Please ask for: Mrs D Johnson
Email: daun.johnson@arun.gov.uk
Telephone: 01903 737762
Our Ref: BR/87/20/PL
Your Ref:
Date: 27th April 2020

Application for Planning Permission

Development: Installation of security shutters to front elevation.
Location: 56 High Street Bognor Regis PO21 1SP

Drawing
Site Location Plan
and Block Plan

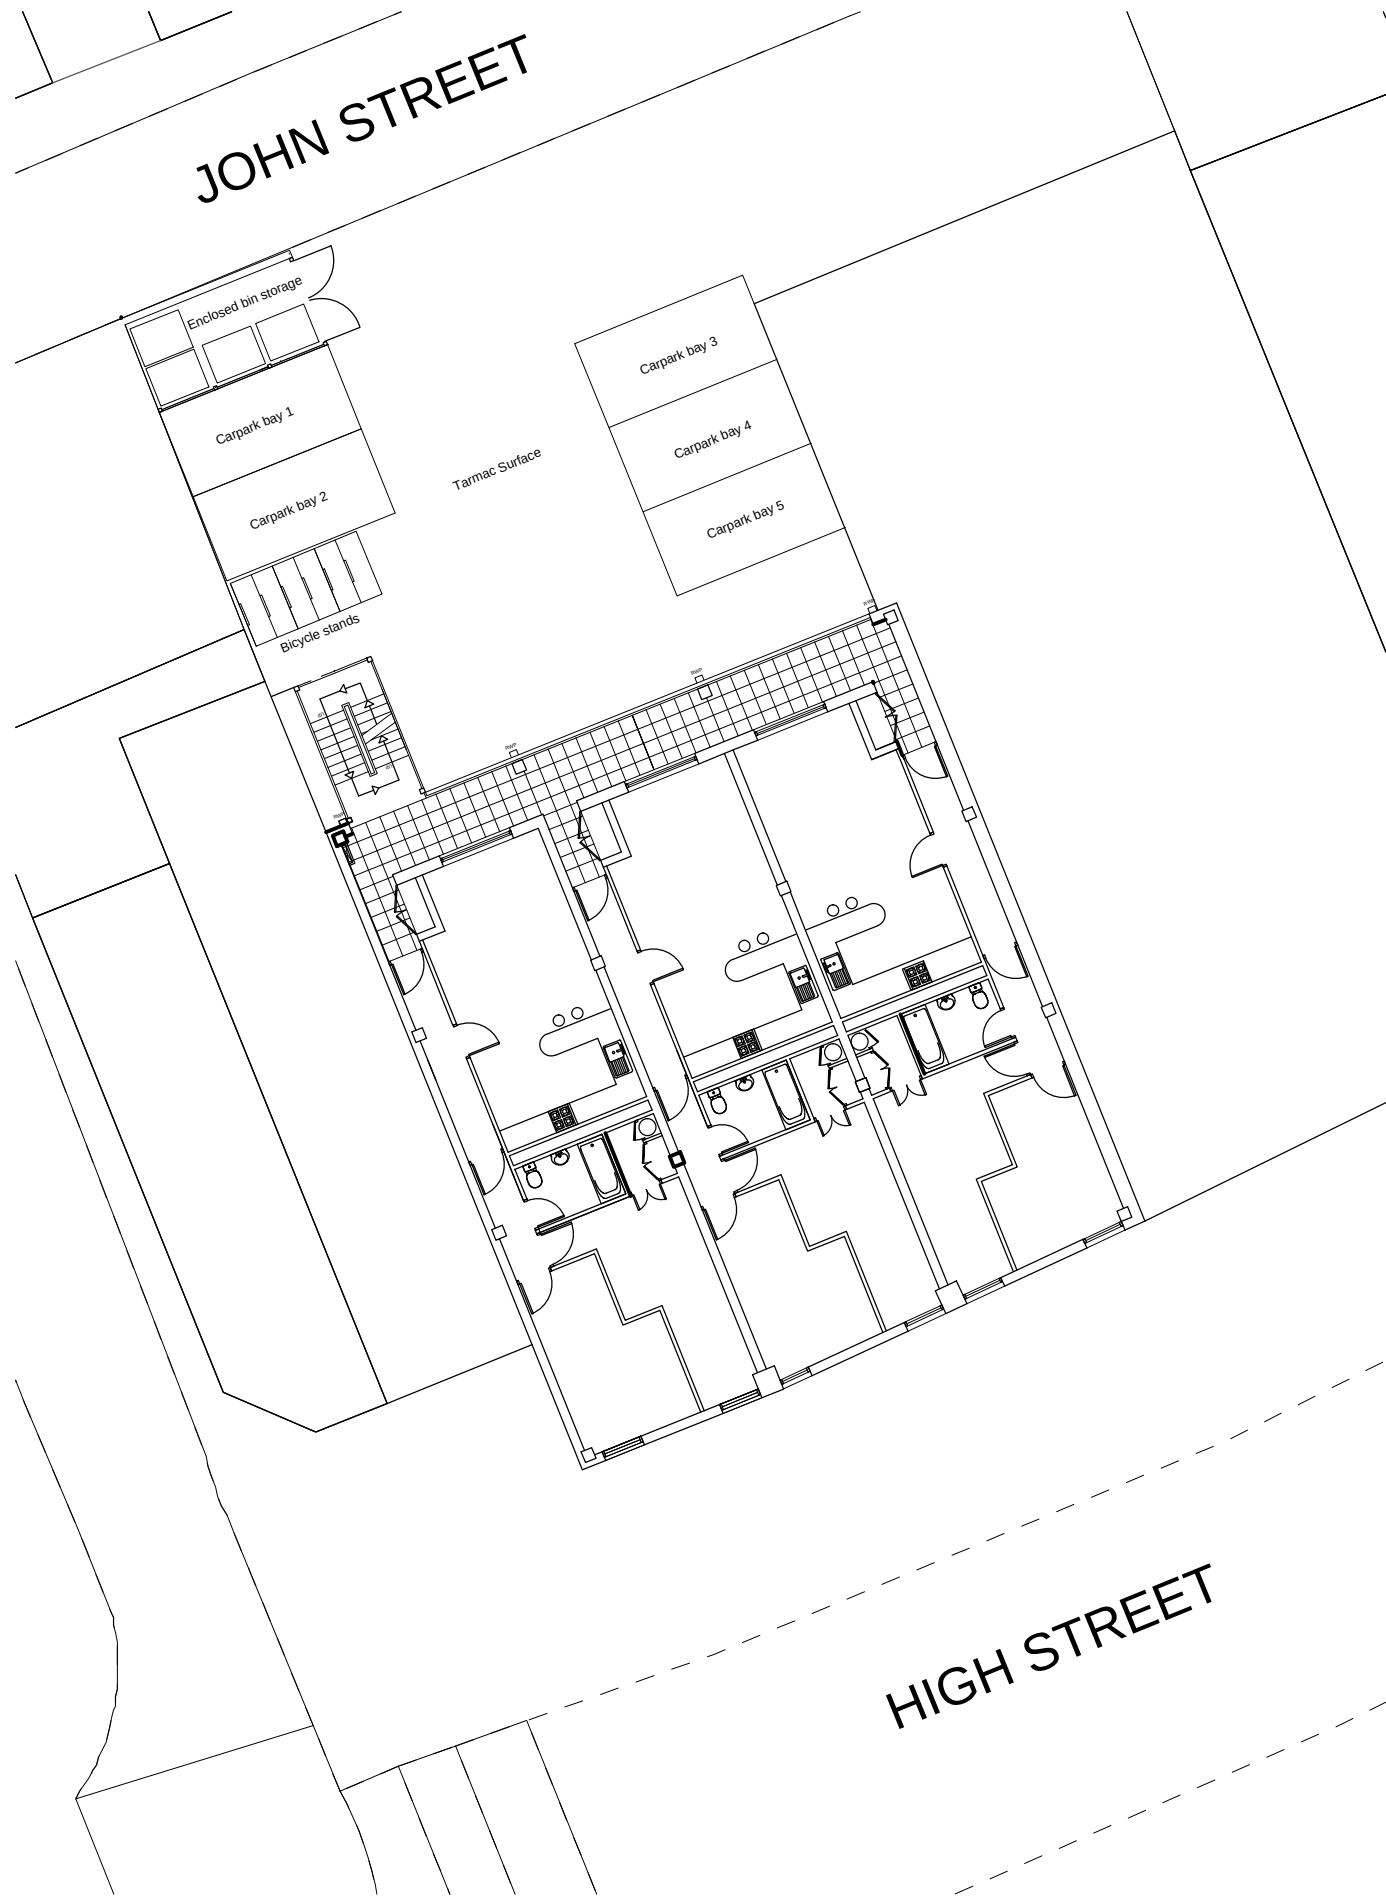
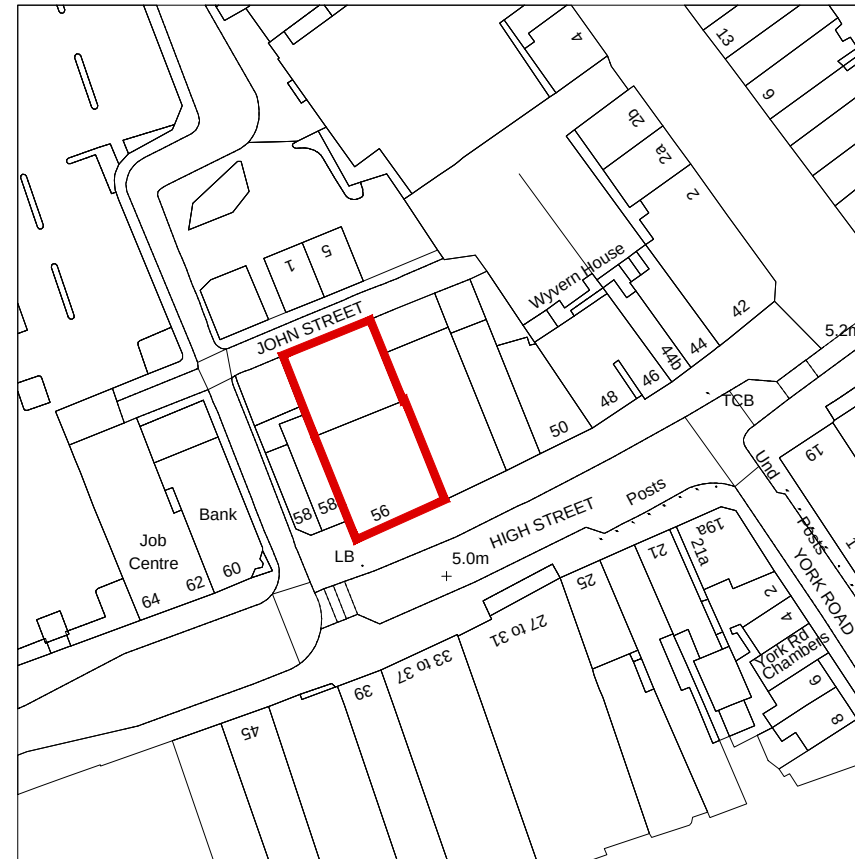
Block Plan

Please clearly highlight the proposal.
CIL Additional Information Form
